Application by Elements Green Trent Limited: Great North Road Solar and Biodiversity Park (Application Reference: EN010162)

Submissions at Deadline 2

Appendix 1 of this letter provides an overview of the documents submitted by the Applicant at this Deadline. Table 1 comprises the application documents for which updated versions are being submitted and summarises how and why the document has been updated.

Proposed Recreation Changes
Figure 18.3(1)

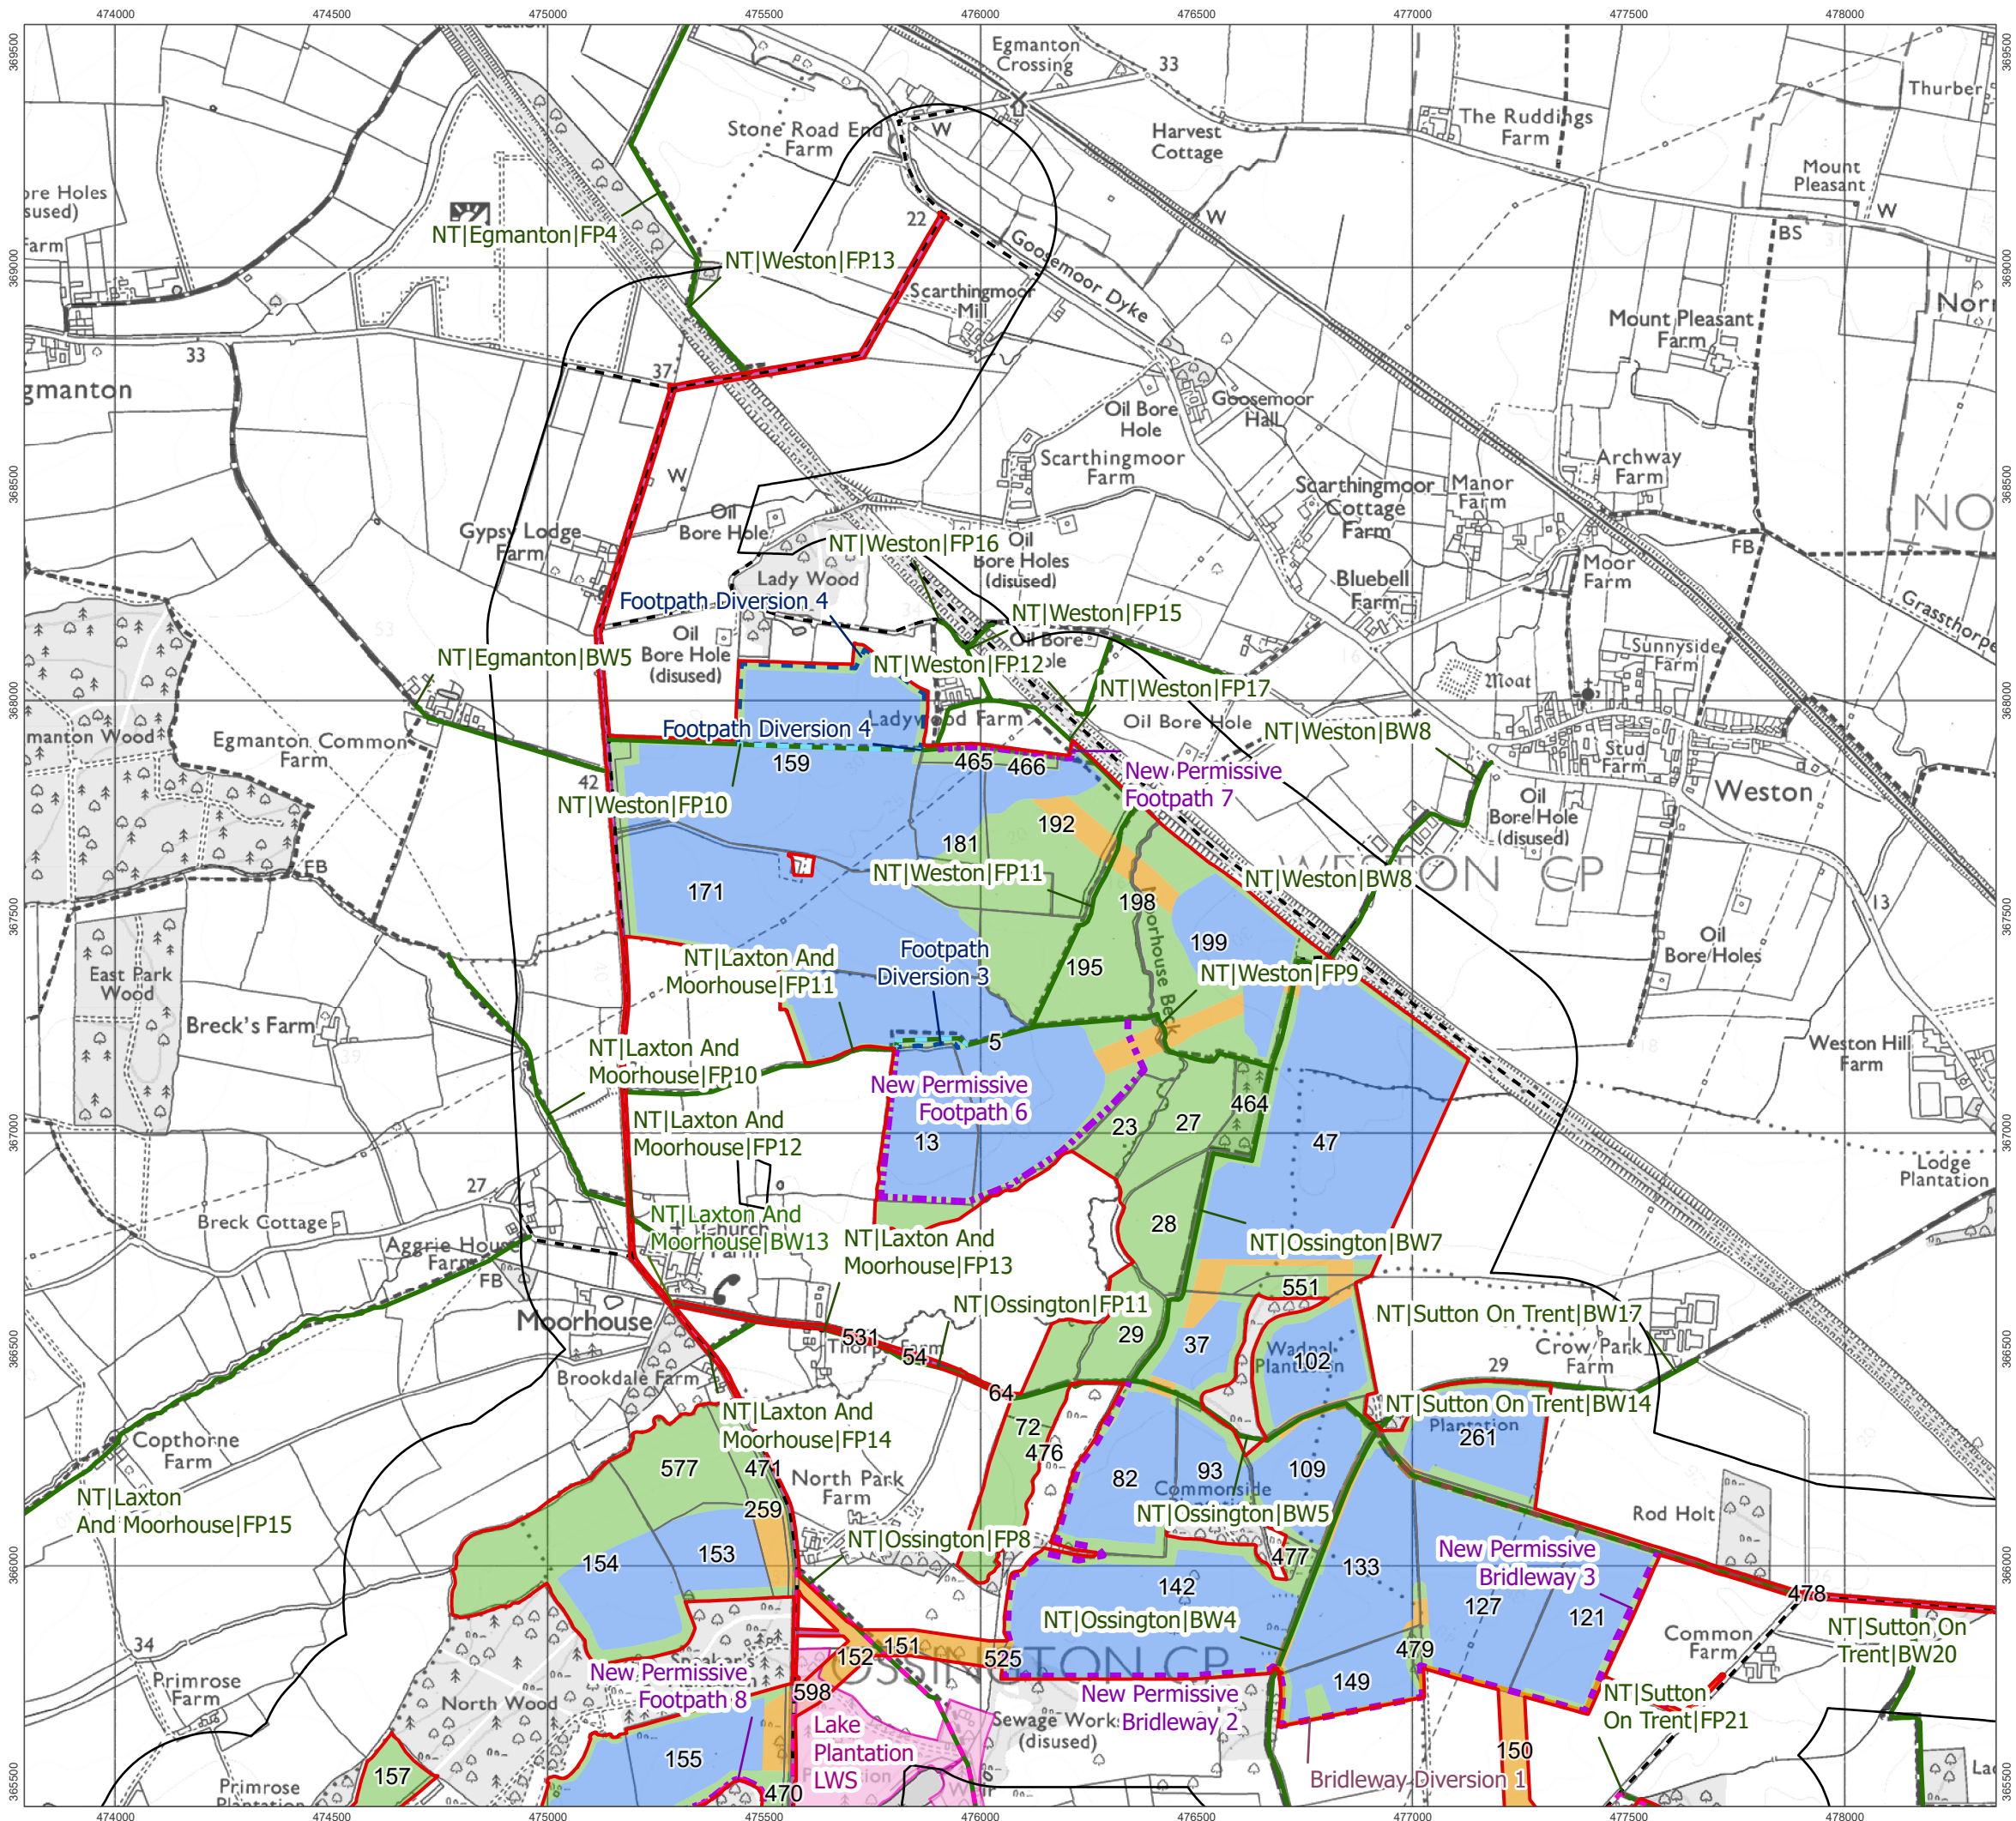
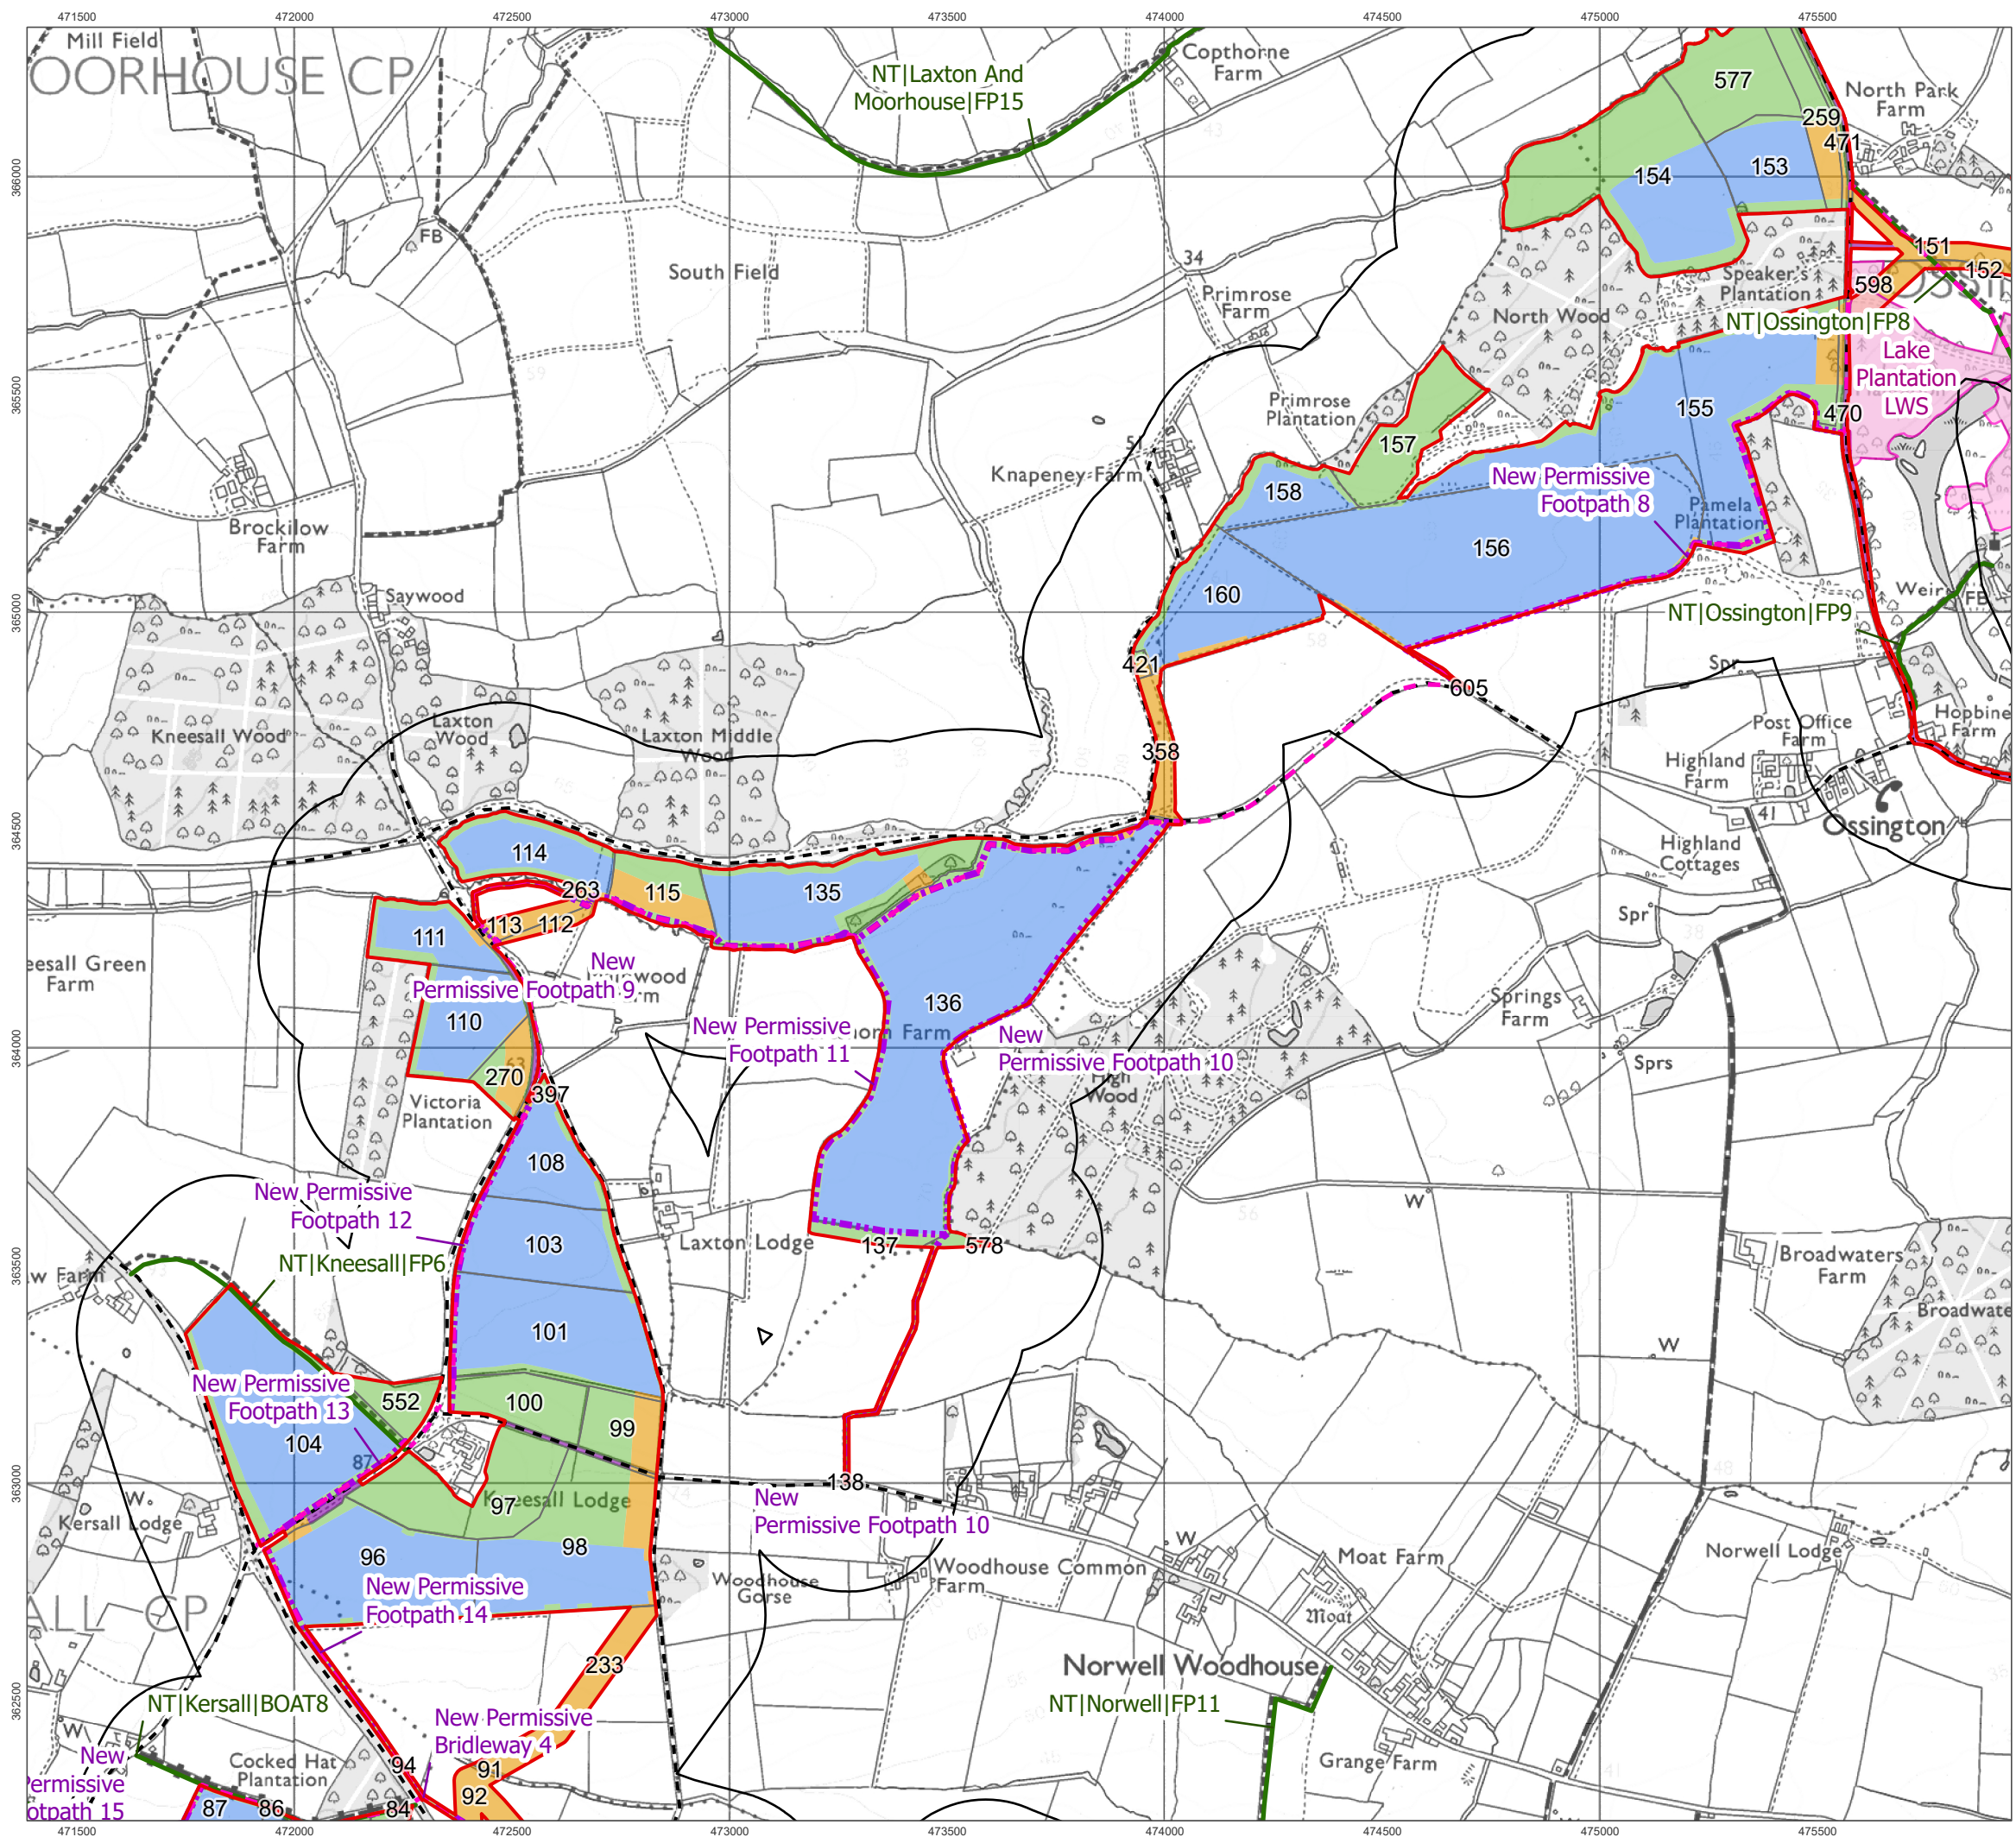
6.3.18B	3	ES Volume 3, Chapter 18 Recreation Figures 18.1 – 18.4	Updated Figure 18.3 Proposed Recreation Changes to remove part of Permissive Bridleway along

Doc Ref.	Revision Number	Document Name	Reason for Submission
			Bridleway Diversion for Construction and Decommissioning only route
6.4.2.1B	3	ES Volume 4, Appendix A2.1: Cumulative Assessment Stages 1 and 2	Update to reflect detailed feedback from NSDC on the list of cumulative schemes.
